**OBJECTION - HORSLEY DRIVE BUSINESS PARK – STATE SIGNIFICANT DEVELOPMENT
APPLCIATION 17161650**

This letter forms an objection to SSD 17161650 due to, the proposed developments potential to create unacceptable impacts on the local road network, safety concerns regarding ingress and egress of heavy vehicles from the warehouse sites and unacceptable internal heavy vehicle circulation at warehouse 3.

Drawing Title
SITE AND GROUND FLOOR PLAN
Project Number
CH HDBP
Drawing Number
DA - 03

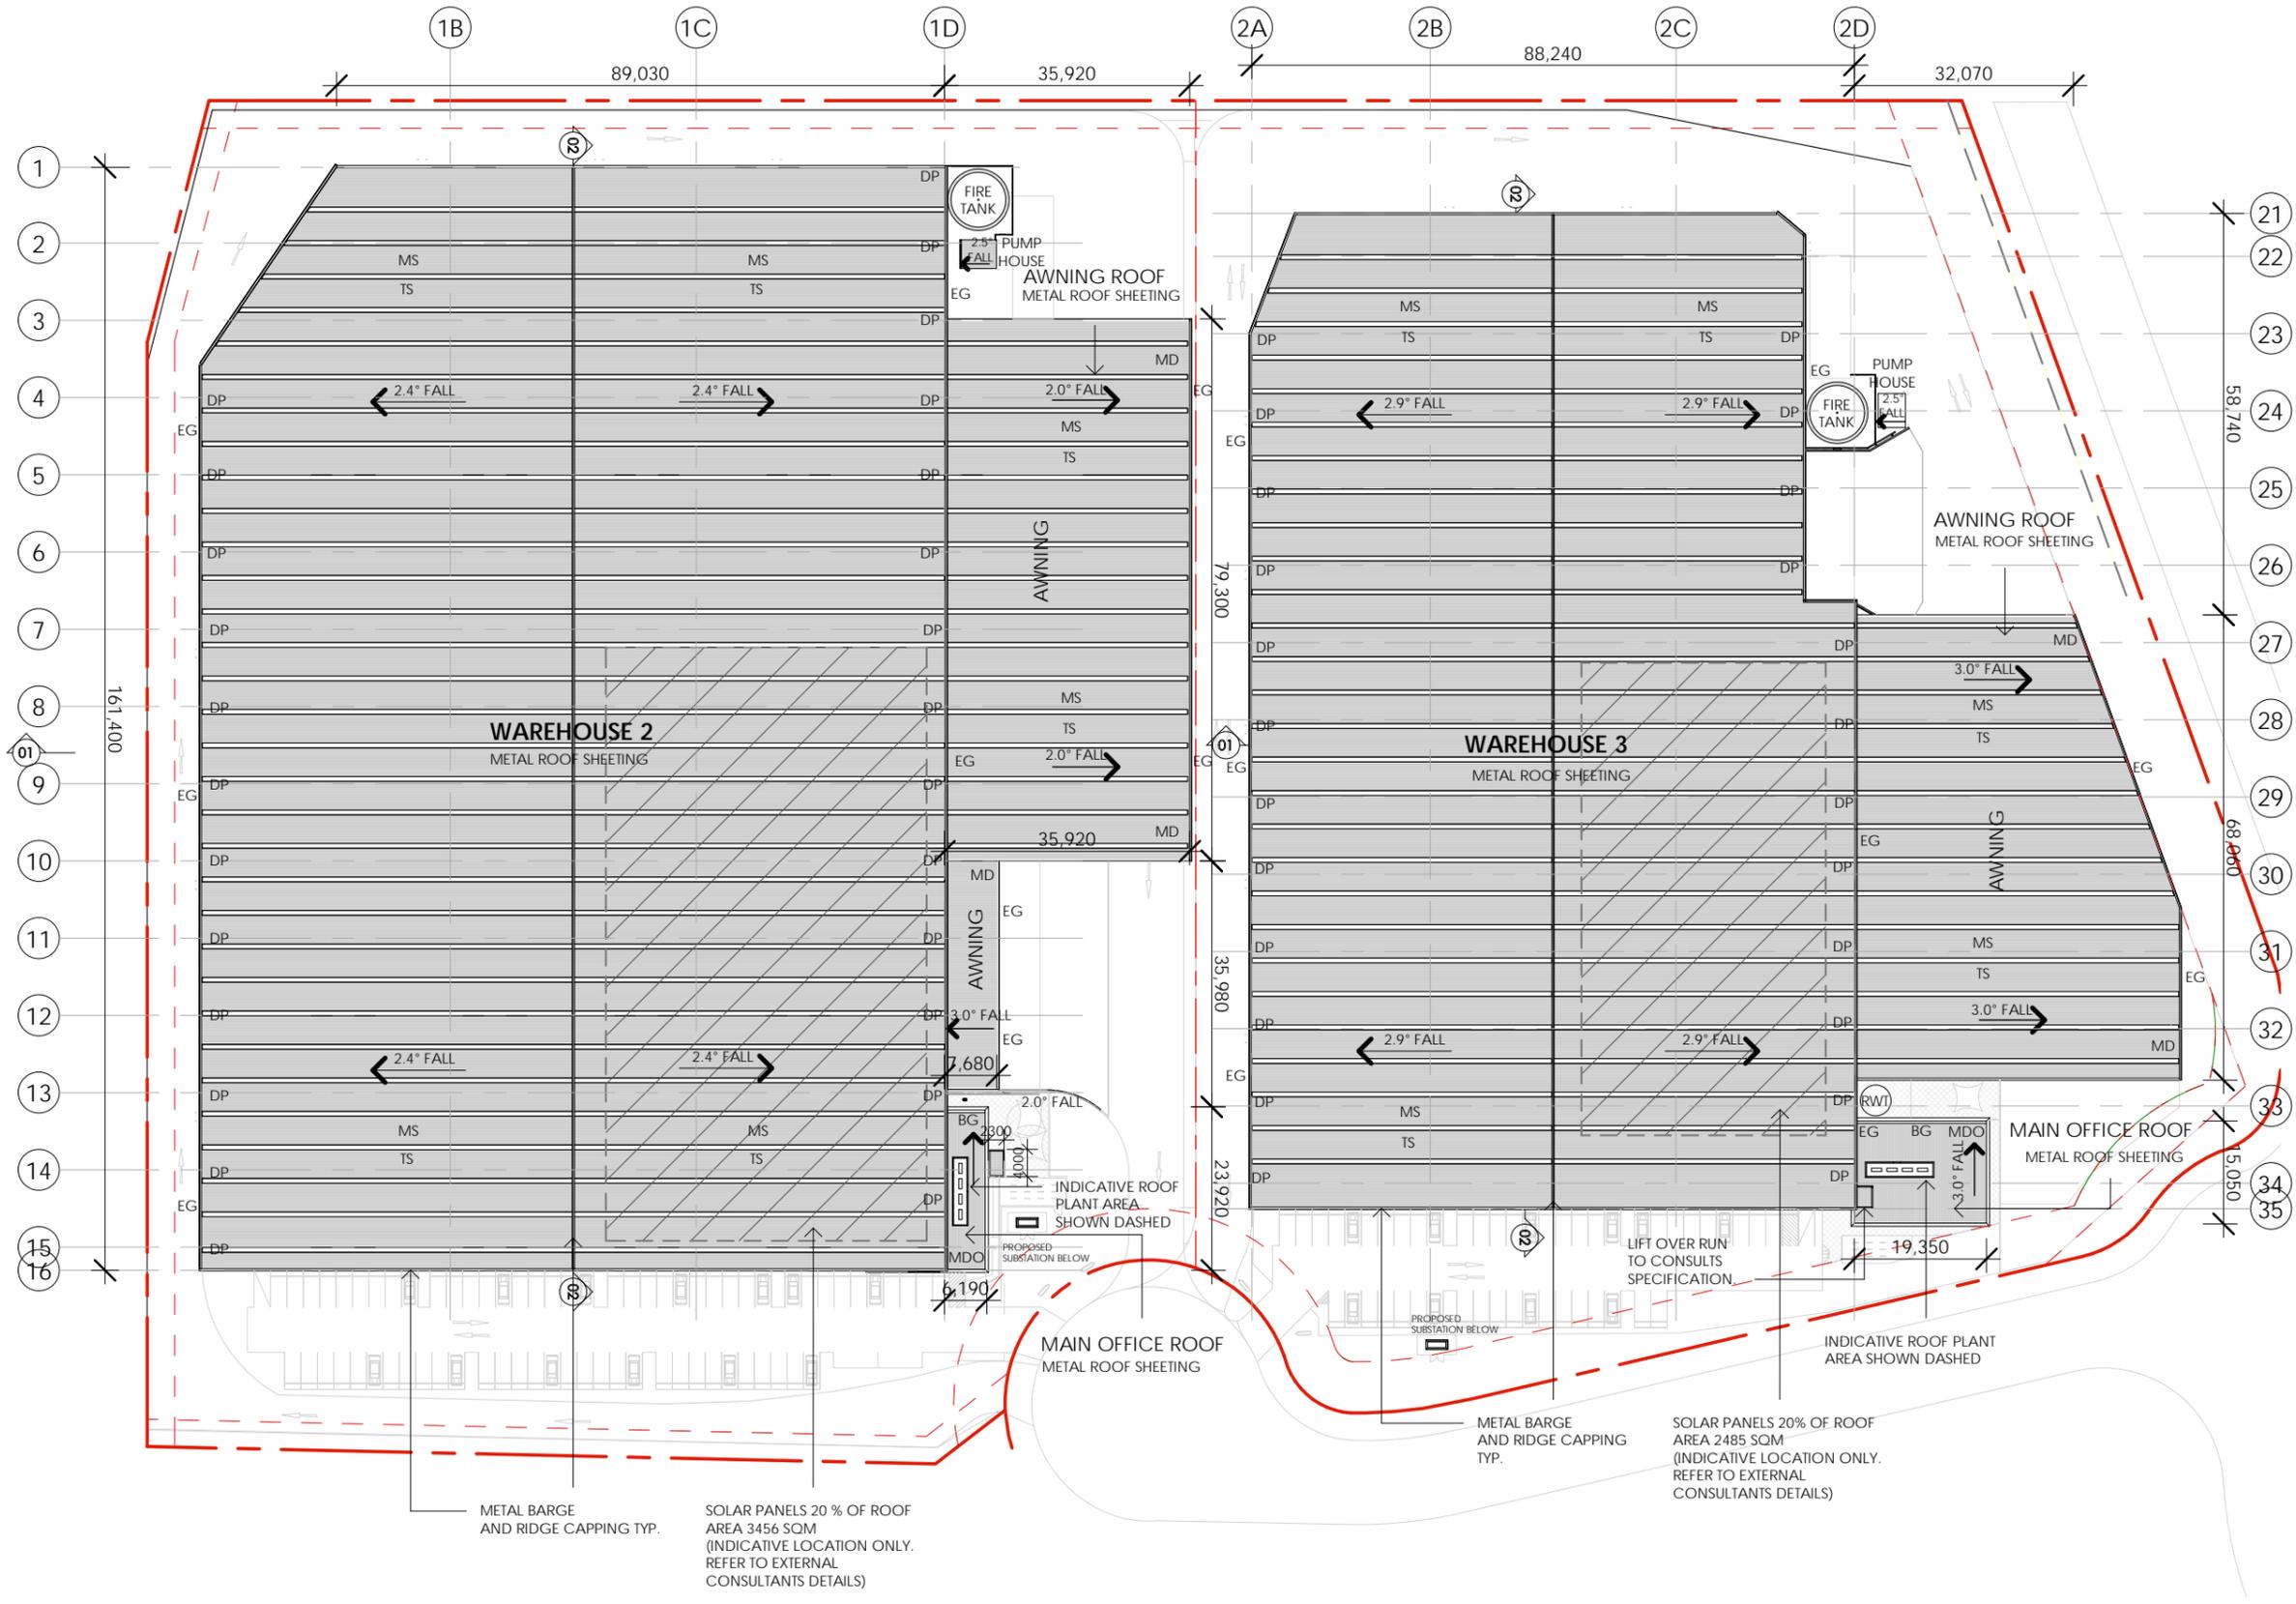
- a. The applicant's OTMP shows, Warehouse 3 is expected to generate 24 vehicle movements (with 7 heavy vehicle movements i.e. 3-4 trucks are anticipated) during the AM and PM peak hours. Based on the applicants' swept path diagrams, the site in its current form would not have the capacity to support the simultaneous movements of 26m B-Double trucks and another vehicle at/near the driveway areas and at the intersections within the site. Where two-way traffic flows are not feasible, the installation of restrictions to allow one-way traffic flow shall be considered.

- b. Unloading/loading along the trafficable area is an issue as it will impact heavy vehicles turning into and out of the recessed loading docks or maneuvering. Consideration hasn't been given to the provision of designated loading bays to accommodate 26m B-Double vehicles to undertake loading and unloading activities. The applicant has not provided a breakdown of the number of heavy vehicles which are anticipated to use the site throughout the day. They have also not provided information on how the potential conflicts between vehicles using warehouse 2 and 3 will be managed.

- c. The swept path analysis shows that it would be difficult for 25m/26m B-Double vehicles to exit the site (turning left out of the site) onto the Estate Road without crossing the Centre of the road particularly with the worst-scenario where vehicles are parking on the Estate Road at/near the site. In this respect the site layout and access arrangement are not satisfactory. Based on the swept path analysis, the development proposal would impact on the surrounding road network's traffic operations and road safety.

- d. Council has not approved the use of traffic signal system within a development site in the past and would not support this treatment unless there is no feasible alternative. No information has been provided regarding the operations of the traffic signal system and about how the potential conflicts between vehicles entering and exiting the site will be managed in the event of a power failure or when the traffic signals are malfunctioning. Unless there are no alternatives and there are justified reasons, the use of traffic signal systems cannot be supported. In addition, Council needs to know how enforcement can be undertaken within a development site (private land) should drivers not comply with the traffic signals.

- a. The truck exit point for Warehouse 2 and Combined Entry / Exit for Warehouse 3 are too close and likely to create confusion to the truck drivers servicing the sites. The access points need to be separated with adequate distance to enable safe entry and exit from the sites.
- b. The B-Double trucks shown at the loading docks at Warehouse 3 appear to encroach onto the manoeuvring areas. The truck manoeuvring areas shall be clear of loading unloading areas.
